Report to be read in conjunction with the Decision Notice.								
Signed:	Officer:	AR	Date:	01/10/26	Manager:	LH	Date:	2/10/26

Application Ref:	3/2026/0453			 Ribble Valley Borough Council www.ribblevalley.gov.uk
Date Inspected:	21/08/2026	Site Notice:	N/A	
Officer:	AR			
DELEGATED ITEM FILE REPORT:				APPROVAL

Development Description:	Proposed single-storey extension to rear.
Site Address/Location:	17 Albemarle Street Clitheroe BB7 2EA

PROPOSED SIDE ELEVATION.

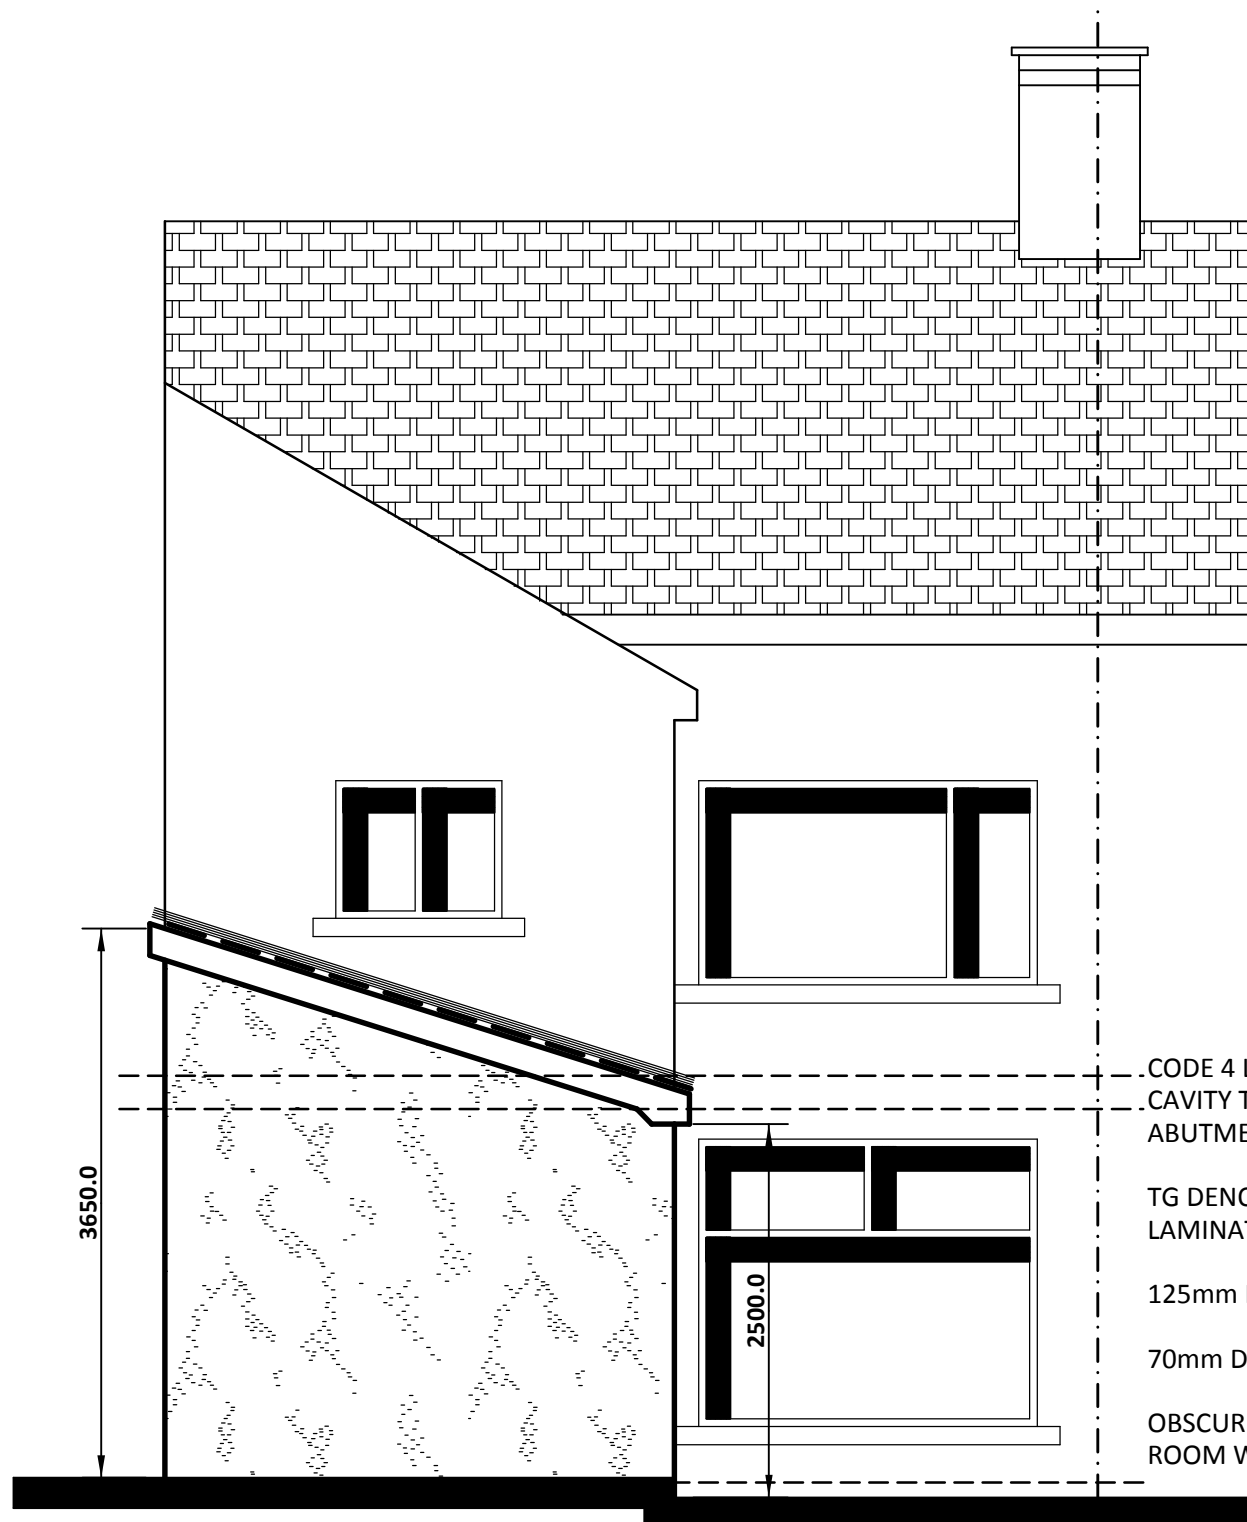
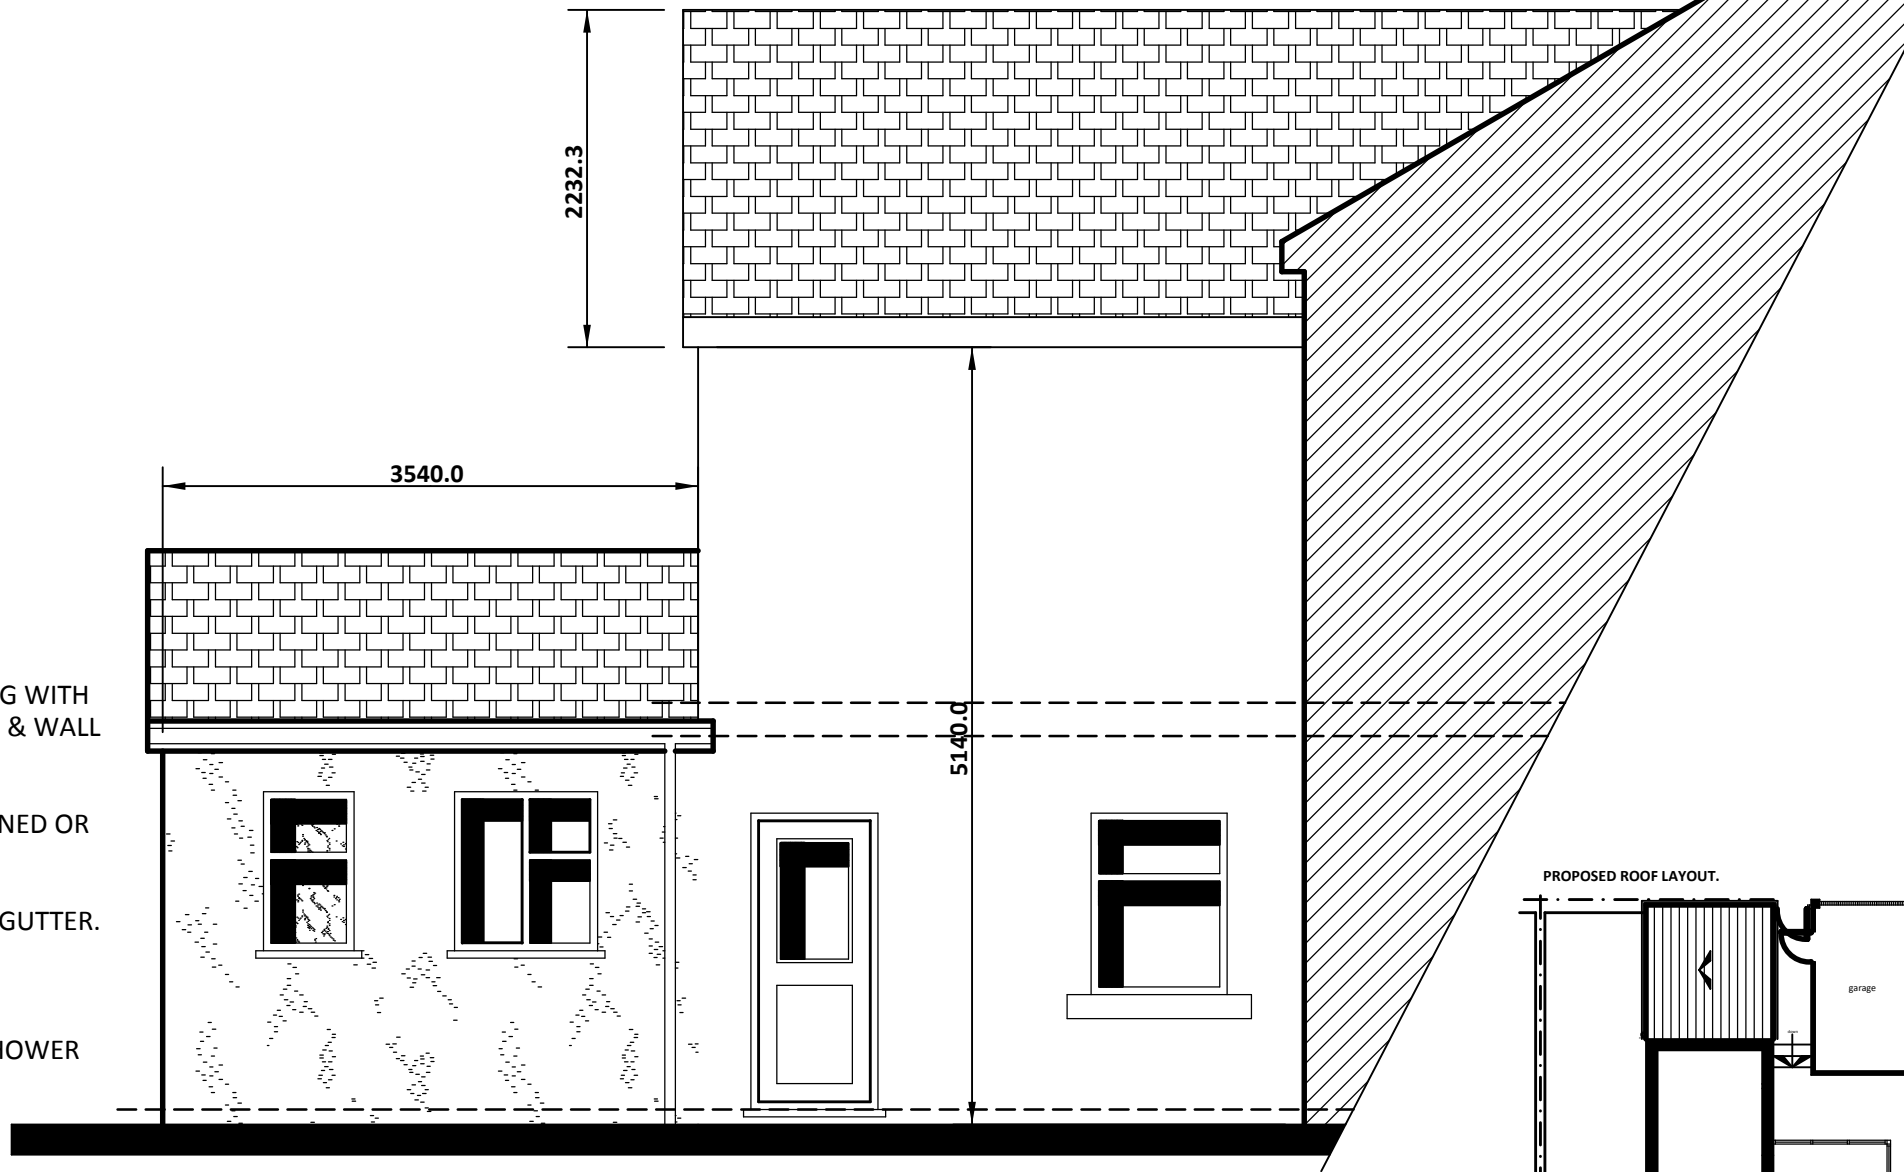
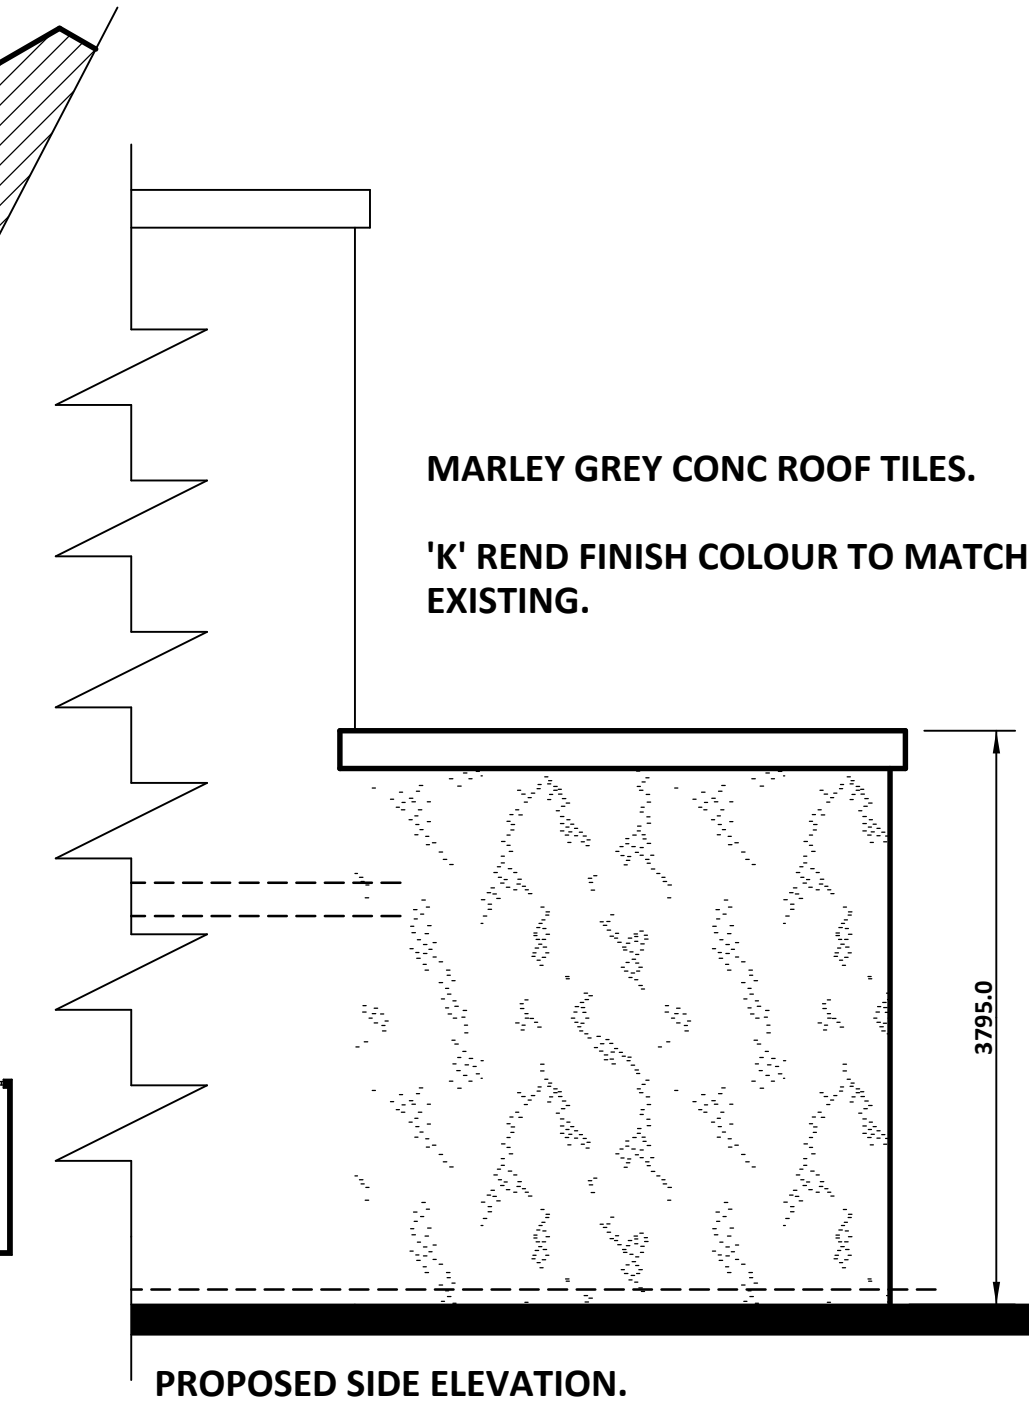
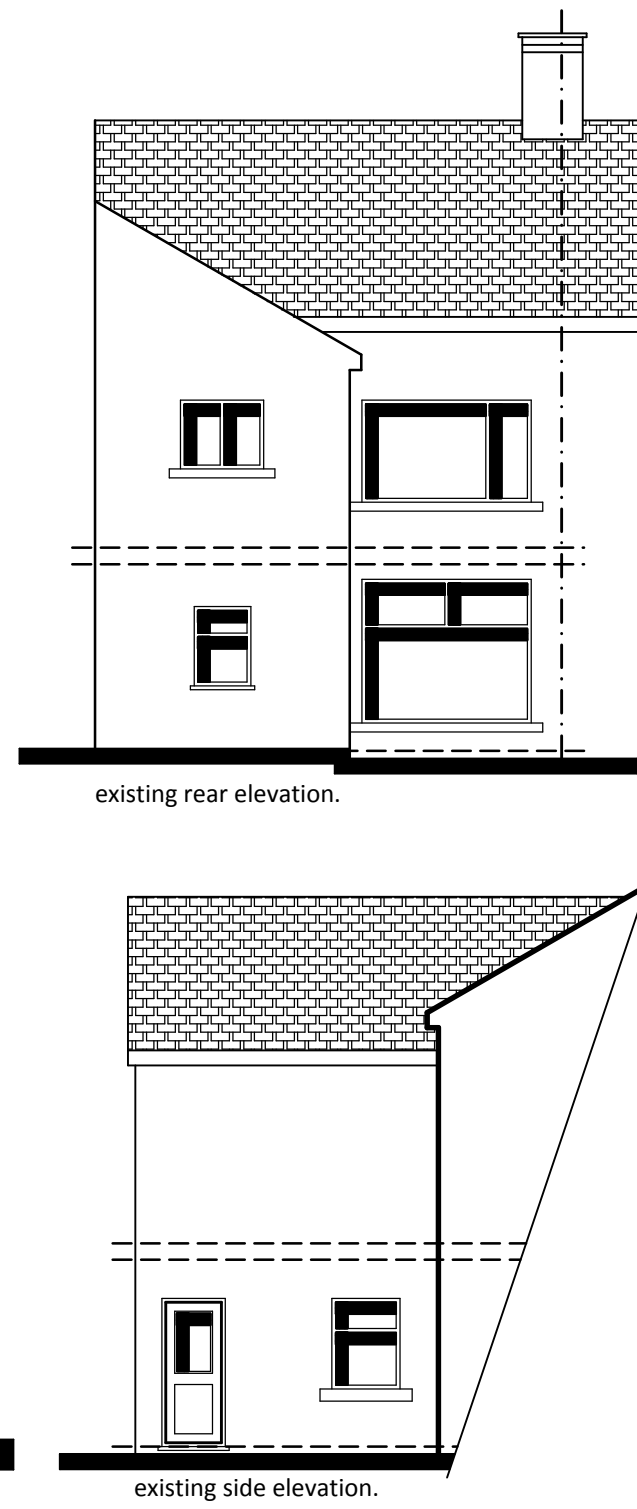
No.2 windows are proposed to the eastern side elevation of the extension, which could have some potential to overlook the neighbouring amenity space. Although there is a stone wall serving as boundary treatment between the proposed openings and the neighbouring property No.15, the height of this wall would not be sufficient to avoid overlooking. However, the proposed openings are modest in scale, and it would be no worse than the current situation whereby both properties have windows that directly look out onto each other. Indeed, No.15 has windows serving a kitchen/utility that currently overlook the application property's amenity space.

Given that the proposed extension will serve as a bathroom and utility room, and taking into account the modest scale and current opportunities for overlooking, the planning officer does not consider that the development would result in a level of overlooking that would make the development unacceptable or warrant a condition requiring obscure glazing.

PROPOSED GROUND FLOOR LAYOUT.

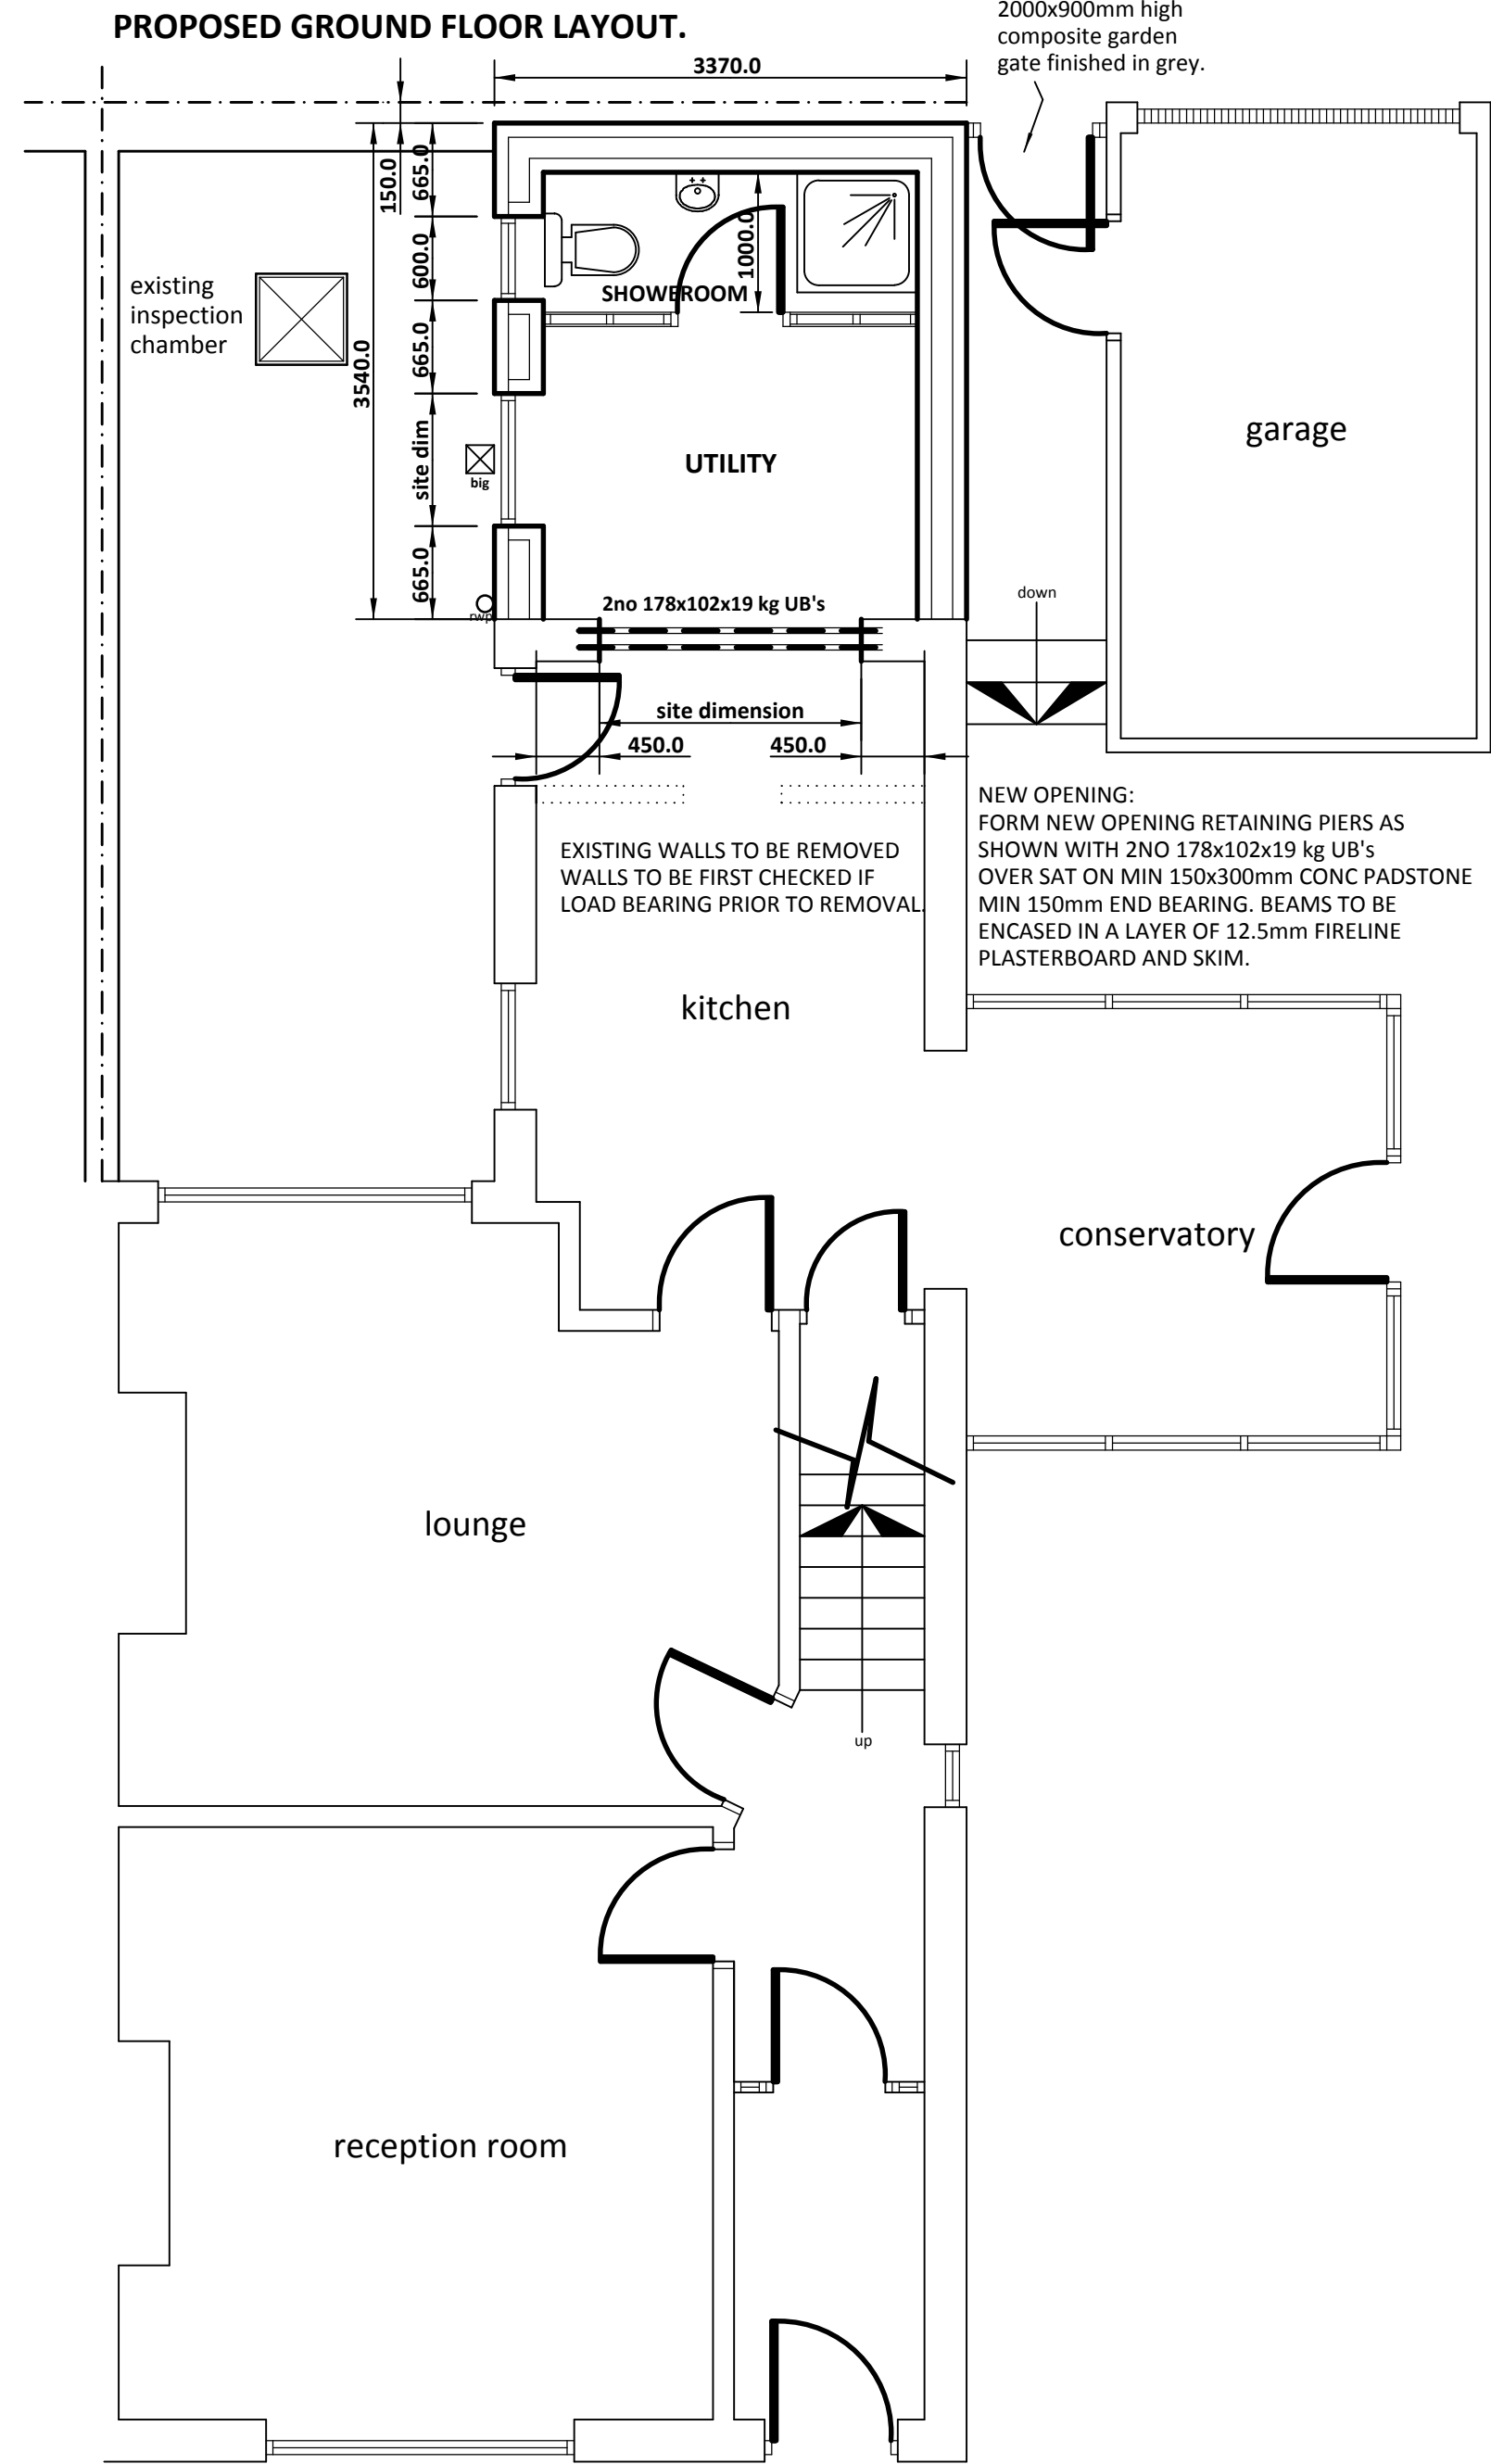
Furthermore, the proposal includes alterations to the boundary wall, with the opening to the side street repositioned to the west of the proposed extension, featuring a 2m by 0.9m composite garden gate finished in grey.

Furthermore, the proposed relocation of the rear access gate would allow for the continued access from the rear garden to a back alley where bins are stored. This proposed composite gate would be 2m by 0.9m, and would not project beyond the existing boundary treatment. As such, this part of the proposal does not inflict any adverse impact on neighbouring amenity by virtue of loss of light or overbearing impact.

Regarding the proposed relocation of the access gate, various types of boundary treatments are found in the immediate vicinity of the site. These include wooden fencing, metal fencing and natural stone walls. Therefore, the 2m by 0.9m grey composite garden gate would not appear incongruous or out of keeping with the surrounding area.
